WEST SUSSEX COUNTY COUNCIL CONSULTATION

TO:	Arun District Council FAO: Anita Gardner
FROM:	WSCC - Highways Authority
DATE:	18 February 2022
LOCATION:	Crete House The Beeches Dappers Lane Angmering BN16 4EN
SUBJECT:	A/266/21/PL 2 No. 2 storey extensions, replace existing bay window with bi-fold doors on the existing dwelling and the construction of 2 No. 5 bed new dwellings. This application is in CIL Zone 2 and is CIL liable as new dwellings.
DATE OF SITE VISIT:	n/a
RECOMMENDATION:	Advice
S106 CONTRIBUTION TOTAL:	n/a

SITE PLAN & VISIBILITY SPLAY
1:200

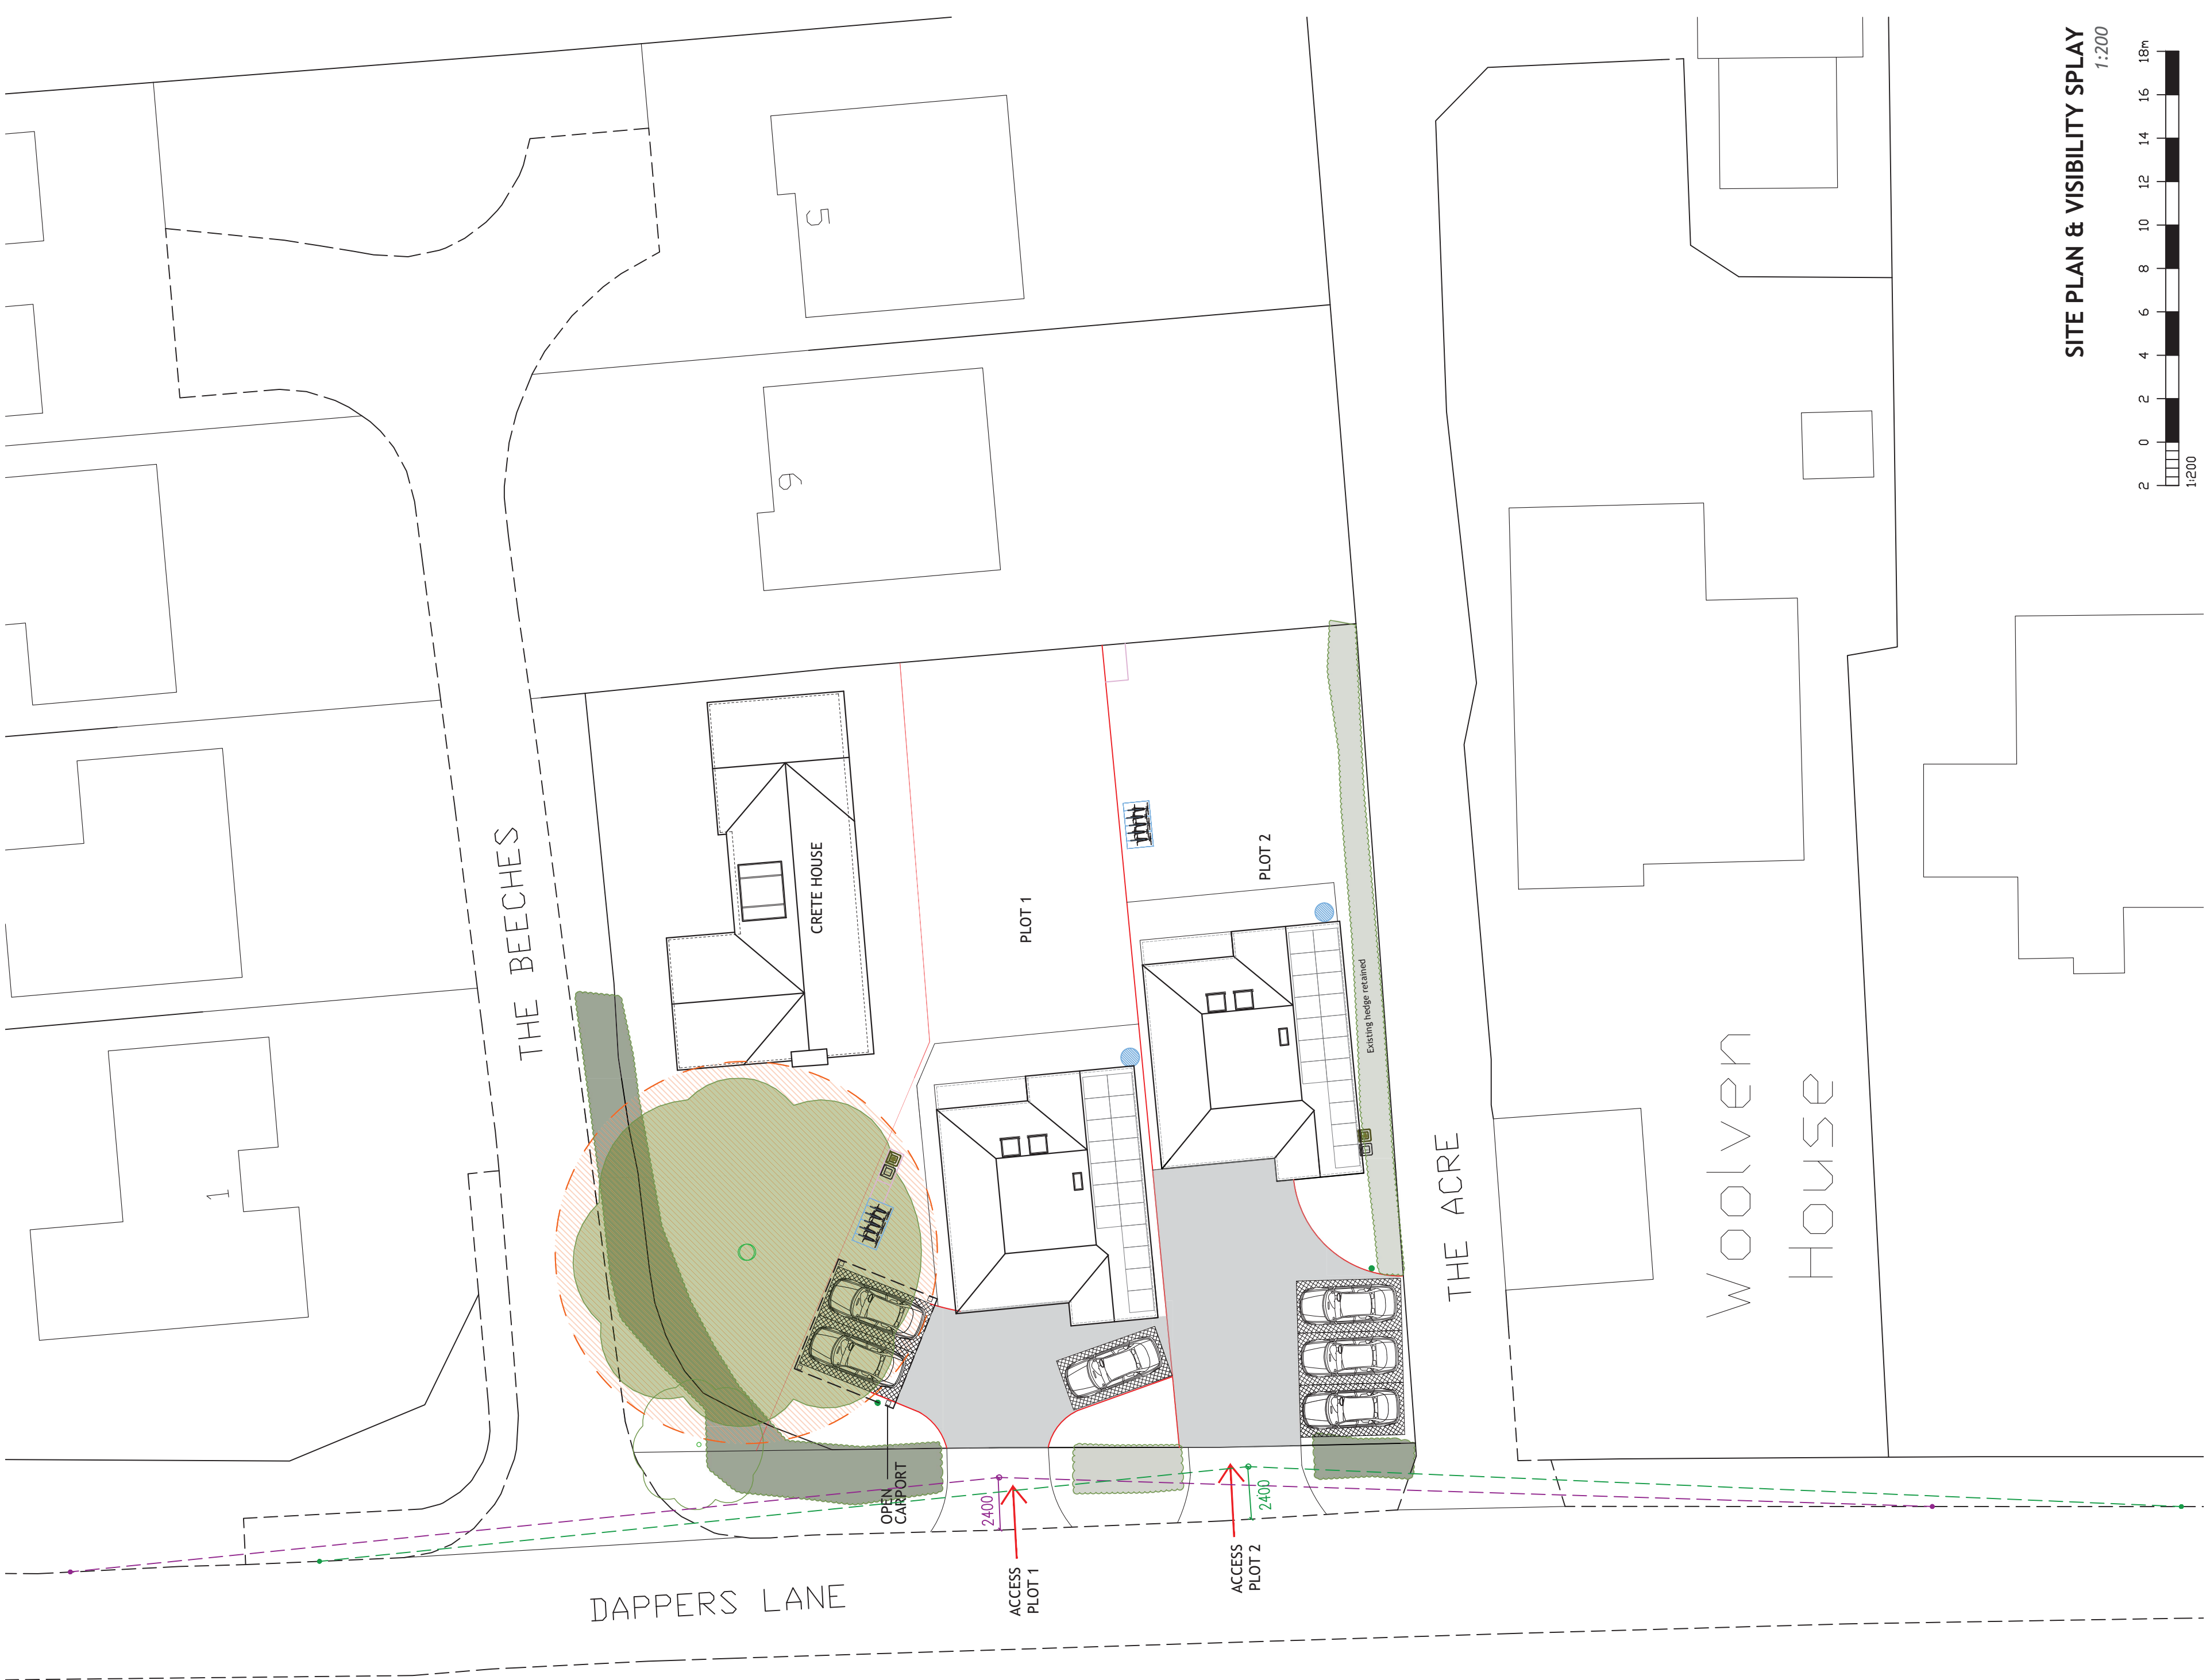
The applicant proposes to implement 2 new access points onto Dappers Lane. The Vehicle Crossovers (VCO) measure at the kerbside, Plot 1 – VCO 6.6 metres and Plot 2 – VCO 7 metres.

The applicant should be made aware that VCO's under 4.5 metres or over 6.4 metres are generally not accepted at the licensing stage. Though in this instance, such a provision is not considered a highway safety concern. The applicant should be mindful that this may result in, if successful, a planning permission that cannot be implemented. Therefore, the applicant is recommended amending the plans to show a kerbside VCO of between 4.5 – 6.4 metres. Details of which can be secured via a suitably worded condition.

The applicant has provided parking for both Plots.

Plot 1 – Parking area 7.2 x 4.8 metres, 3 spaces with 100% EV coverage.

Plot 2 – 3 parking areas measuring 2.4 x 4.8 metres each with 2/3 EV coverage.

The LHA raise no concerns over the above, the LPA may wish to condition EV parking to be provided at 100% coverage.

The use of the car parking space(s) shall not commence until the vehicular access has been constructed in accordance with plans and details **to be** submitted to and approved in writing by the Local Planning Authority.
